Outer Dowsing Offshore Wind Farm

Appendix C7 to the Natural England Deadline 6 Submission
Natural England's Advice on Benthic Ecology

Planning Inspectorate Reference EN010130

4th April 2025

Contains ESRI Basemapping;  
 EMDOnet 2020 bathymetry

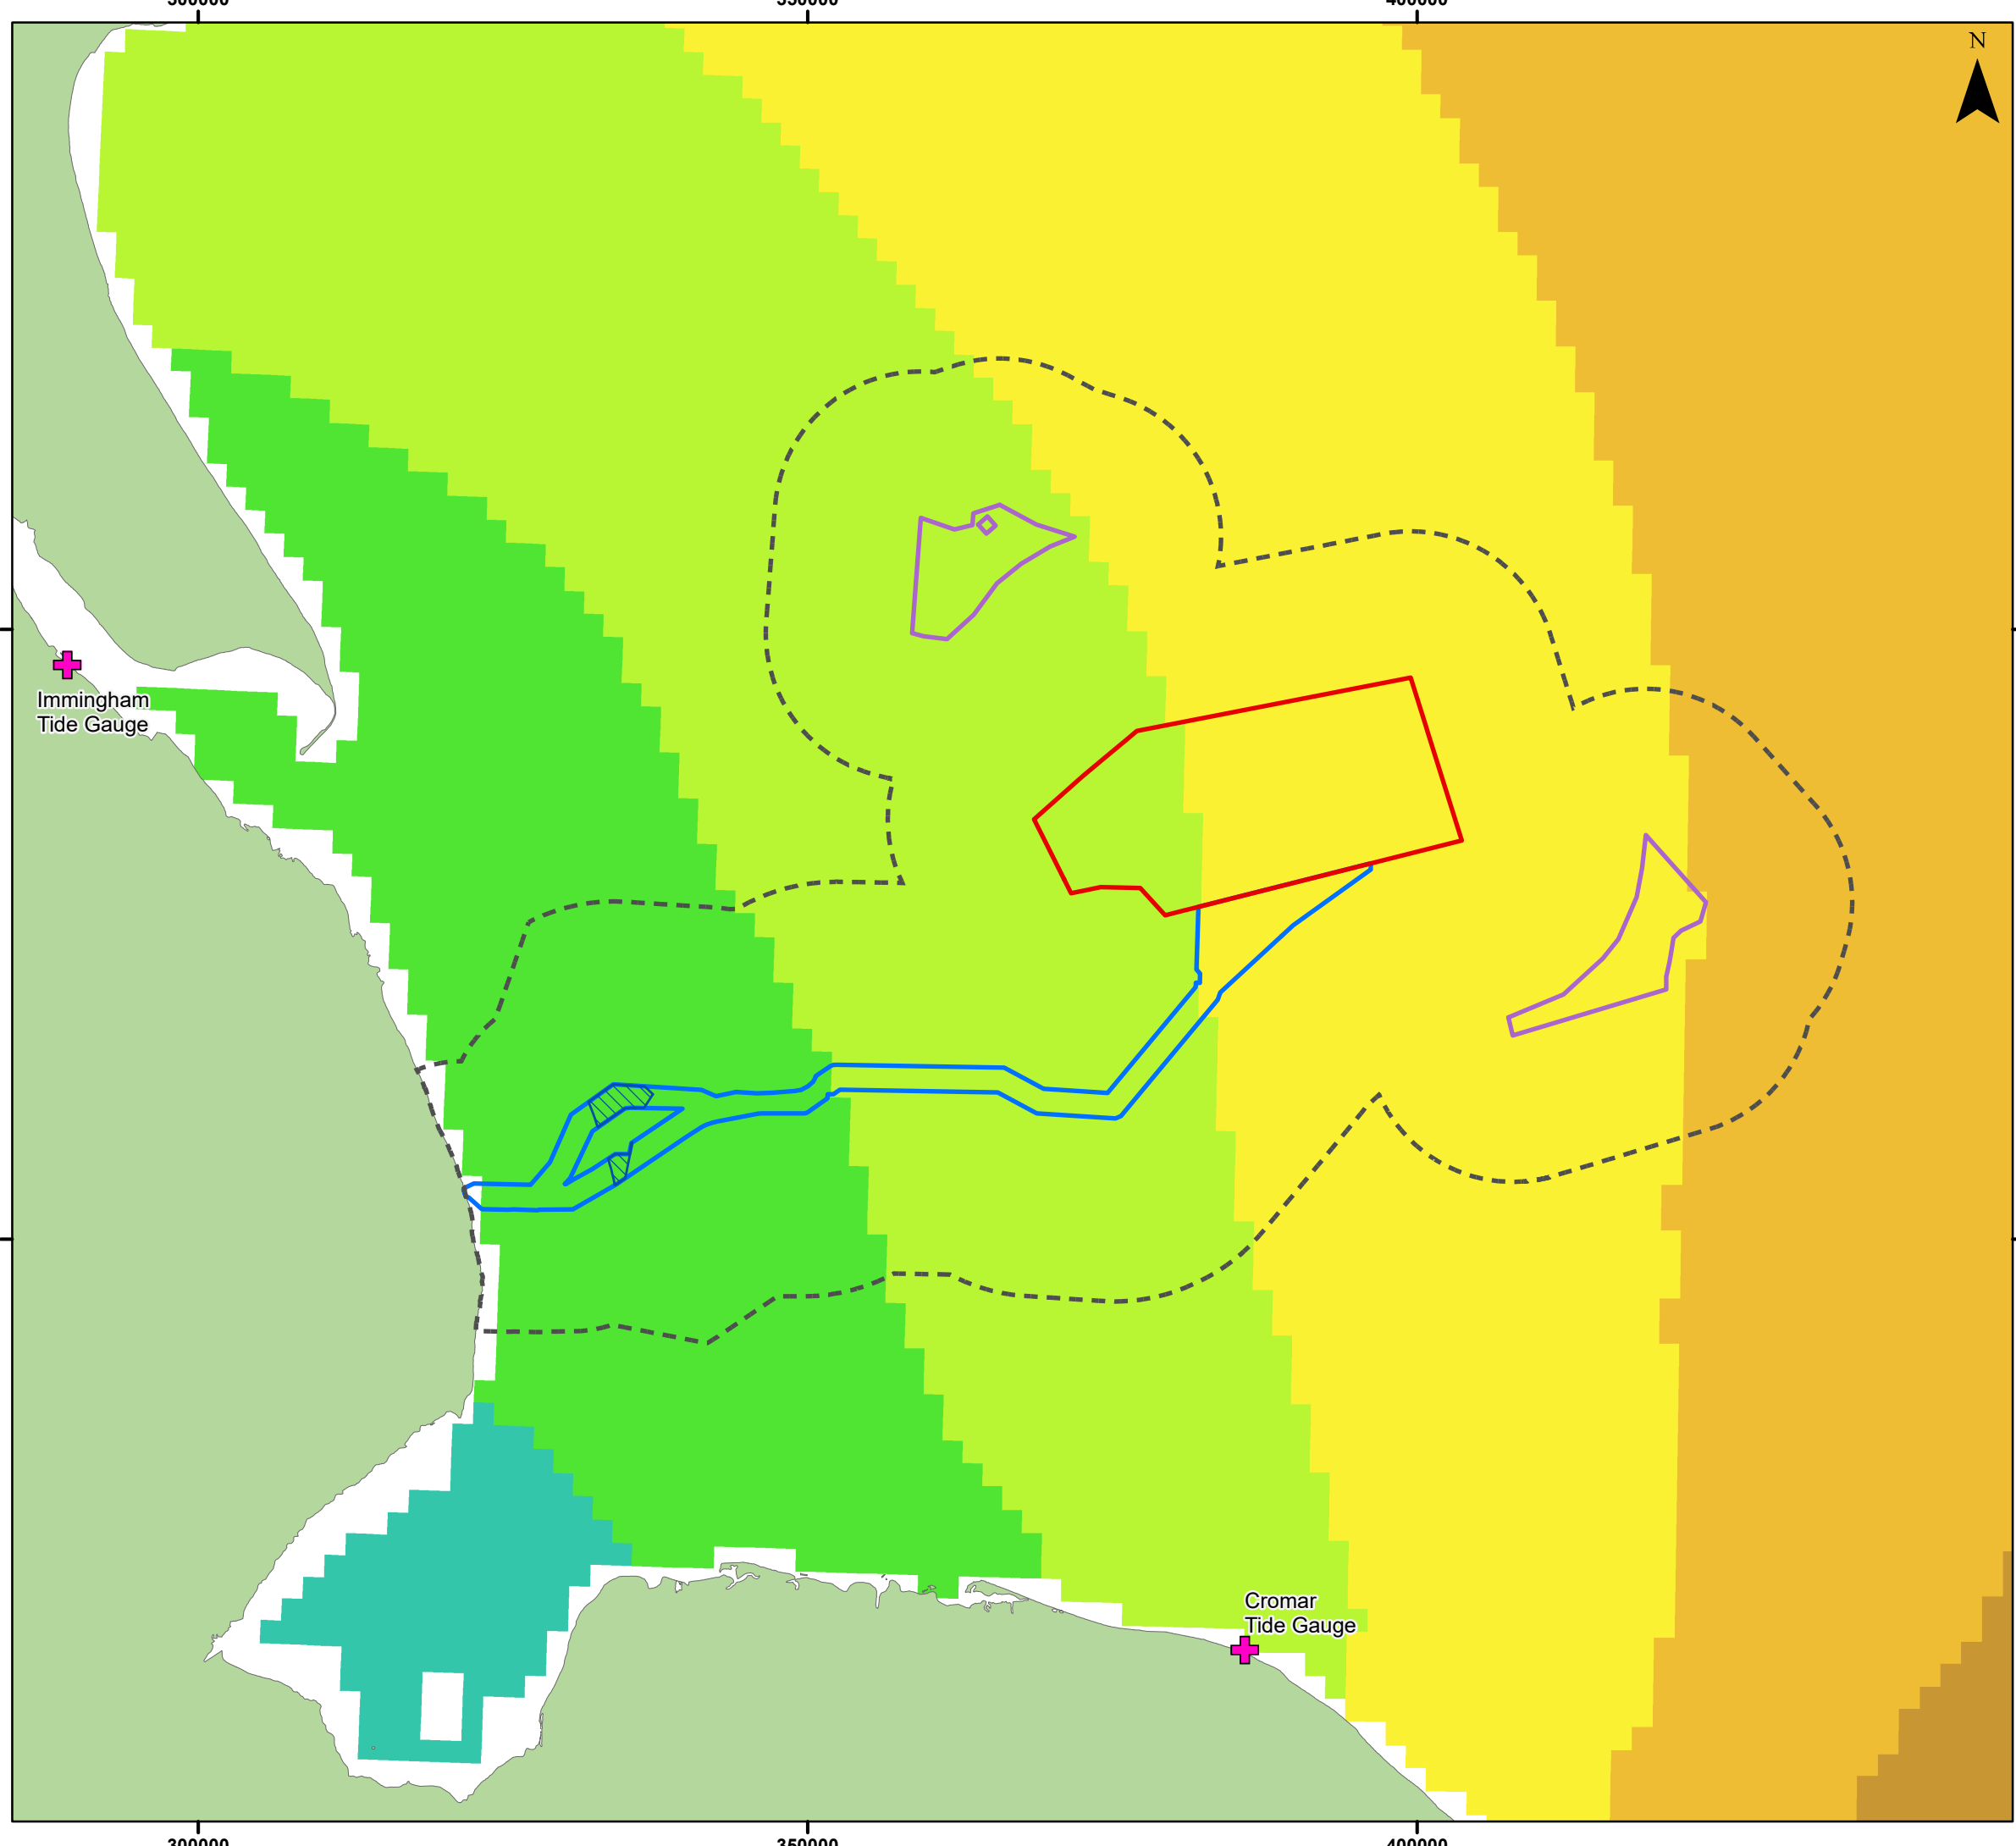
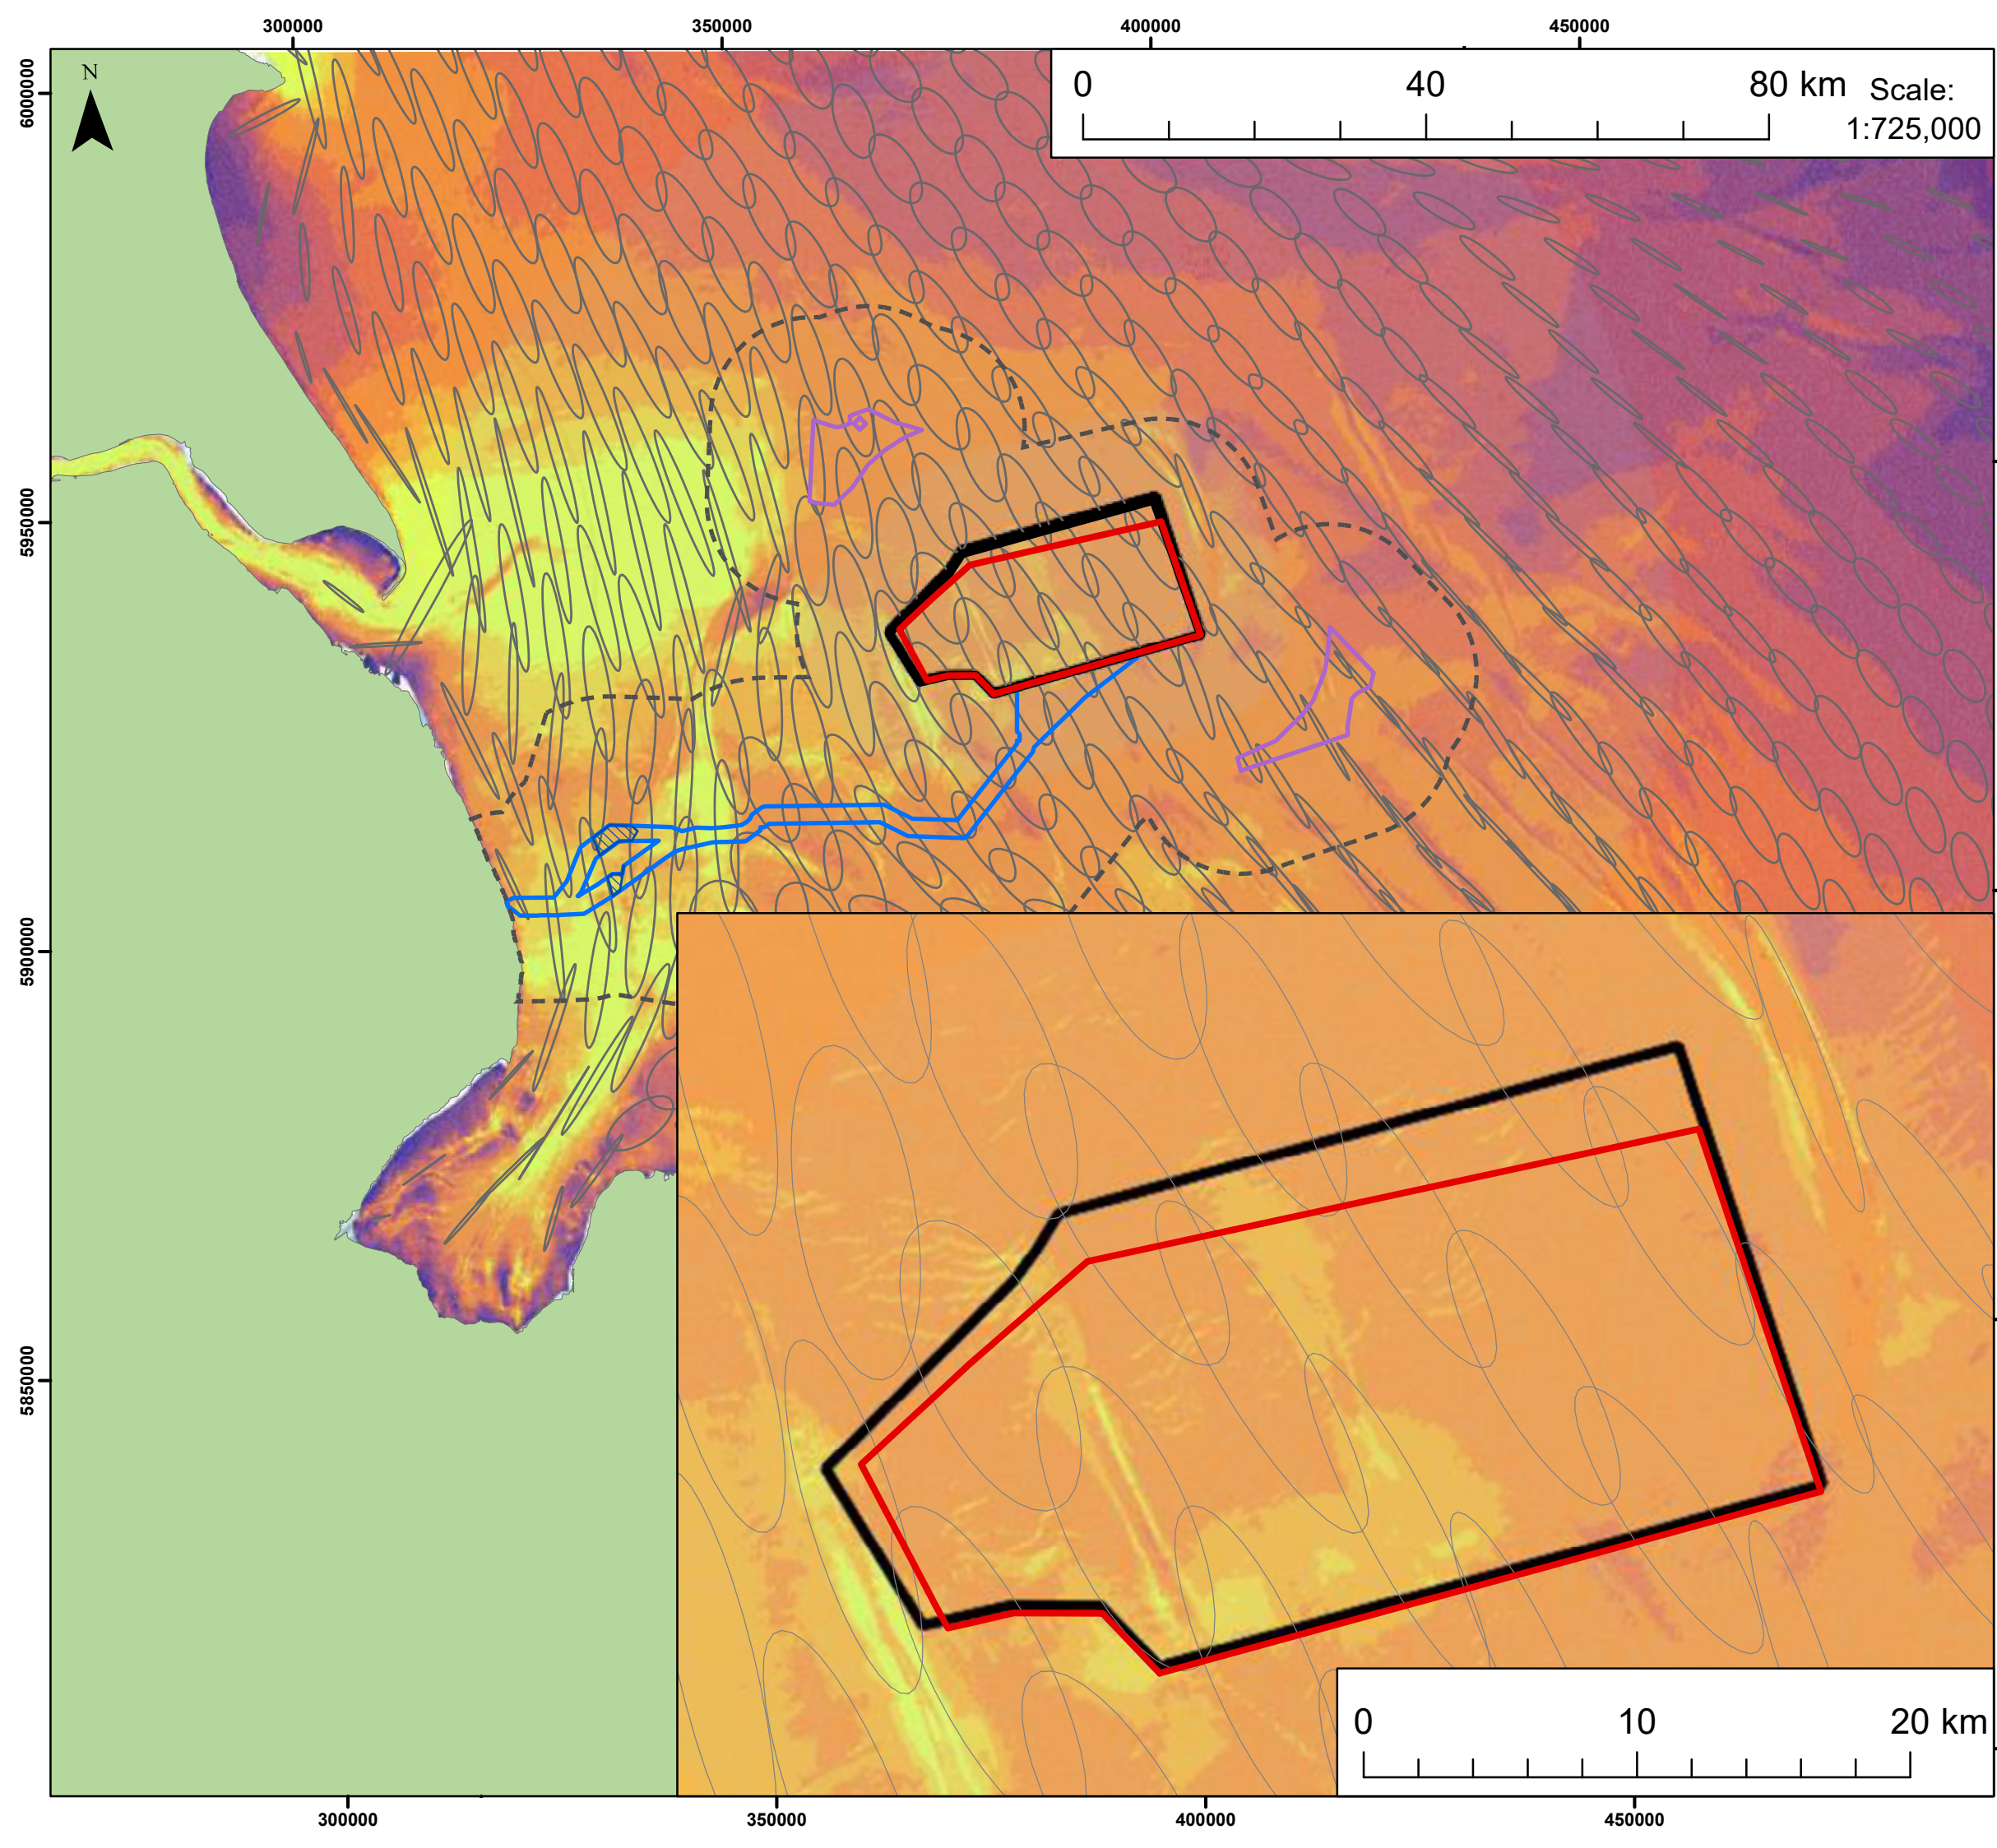
- 1. NE previous advice: Table 2, optional parameter 1 – It is not clear if this parameter has considered dominant direction tidal flows which would require an increase in the buffer from 2km to 3km. The figures in ‘Chapter 7 Marine Physical Processes Figures Part 1 of 2’ demonstrate that the dominant tidal flows and bedload transport across the ECC are in the NNW and SSW directions, and as such, we advise that the 2km buffers applied should be extended to 3km to align with the description of optional parameter 1 within the Technical Note.**

ODOW response: The Applicant notes difficulty in interpreting ‘Optional parameter 1,’ specifically the phrasing: “*within 2 km of sandbanks in any direction OR within 3km in the direction of tidal stream, whichever is the greater* 2.” Our initial interpretation was that the worst-case area for the majority of the Offshore ECC was ‘within a 2 km radius of the sandbanks’. This interpretation arose due to the direction of the tidal stream (approximately NW-SE/ N-S, see Figure below which presents tidal ellipses), we therefore did not anticipate that this would have a greater impact on the width of the corridor than the 2 km buffer applied around the entire sandbank.

Furthermore, there was additional confusion surrounding the phrase “OR within 3km in the direction of tidal stream,” as it does not clearly state what the 3km buffer is associated in relation to the tidal stream – we assume that this would be the northern points of the sandbanks for the current features of interest. We have mapped the tidal ellipse data (see figure below), which demonstrates that a 3 km buffer could be applied to the north of the sandbank features, specifically “in the direction of tidal stream.” This would result in two small areas highlighted by the red cross hatch in the figure below being included as supporting habitat. This additional area is 2.5km². As illustrated in the figure, no other additional adjustments in relation to ‘Optional parameter 1’ are necessary.

Natural England welcomes the addition of the 3km buffer to the north of the sandbank features. While this satisfies our previous advice; to ensure joint understanding of the approach, we highlight that according to the methods outlined within the Applicants [*Sabellaria spinulosa* reef supporting habitat Technical Note: February 2025], much of the red cross hatch area which we have annotated with number ‘1’ below should have been already included as supporting habitat owing to the presence of the ‘SS.SBR.PoR.SspiMx - *Sabellaria spinulosa* on stable circalittoral mixed sediment’ which has been mapped in that location (in alignment with optional parameters 2 and 4).
